**Consultation Response from KC,  
Lead Local Flood Authority**

**2023/91491 Prickleden Mills, Woodhead Road, Holmfirth, HD9 2JU**

**Date Responded: 10<sup>th</sup> June 2023**

Figure 5.3 Floodplain Compensation Usage

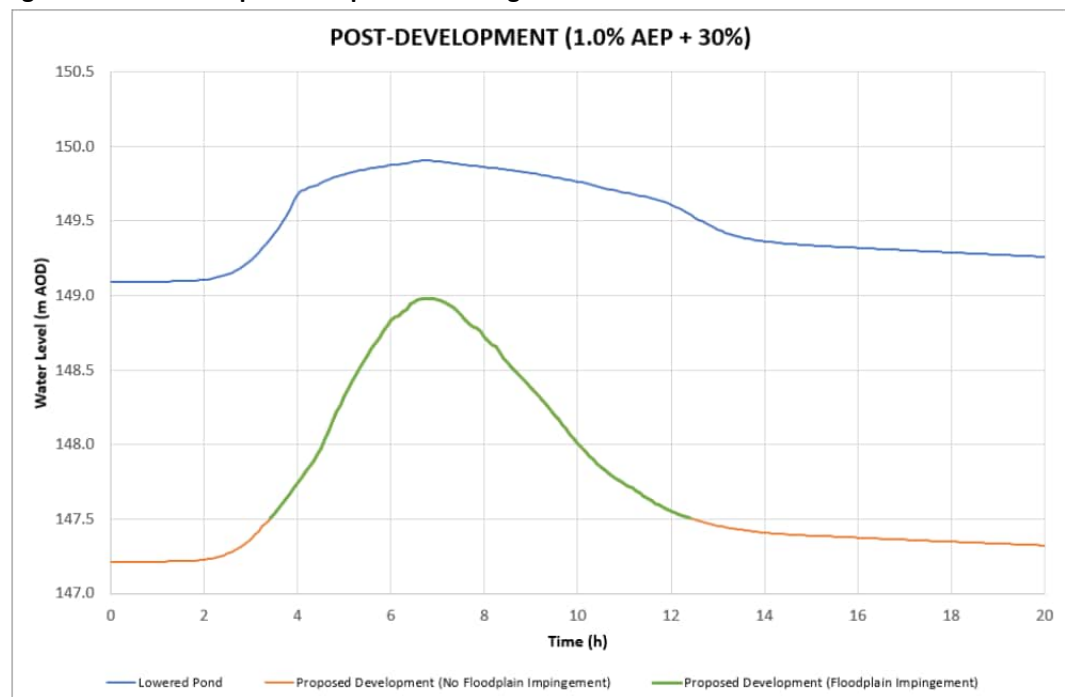
No assessment of the mill pond has been included. Previous surveys including the Council's assessment of risk from mill ponds are available but are now 10 years old and need to be updated by the applicant. As a result, no mitigation plan to upgrade the pond is forthcoming including emergency drain down methods.

Any attempts at compensatory storage must be assessed by the Environment Agency.

Figure 5.4 **Location of Undercroft Car Park**

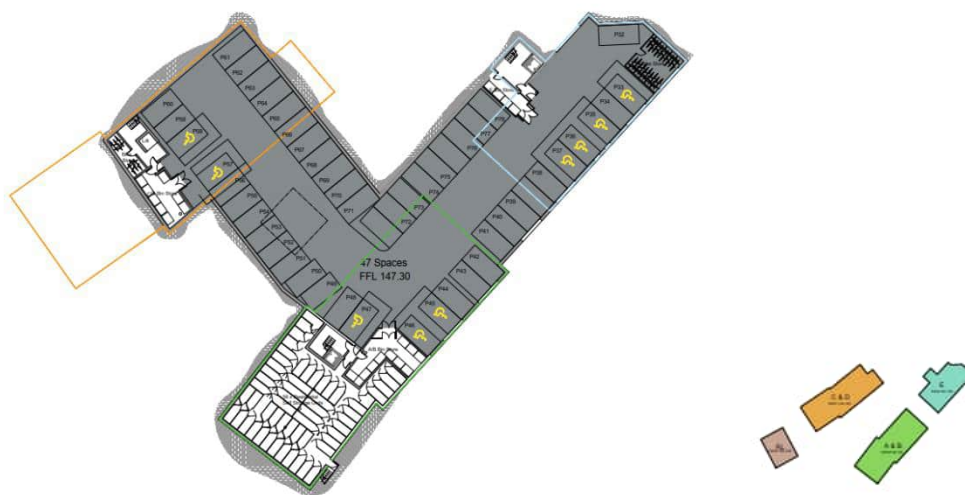
The potential flooding of under crofts is unacceptable. It introduces a flood risk not currently present and could be life threatening.

Wall defences are promoted to mitigate flood risk from main river which could inundate the under-croft parking area. We should assume that defences fail when looking at main river flood risk because of potential (ineffectiveness) and long-term maintenance requirements. We would object to this and request the planning officer discusses with the Environment Agency. The risk of flooding the under croft is life threatening. Such defences would only be considered for residual risk after standing avoidance and mitigation practices. Given the basement location and potential rapid inundation this may need to be considered for the 1 in 1000-year event to avoid serious risk to life.
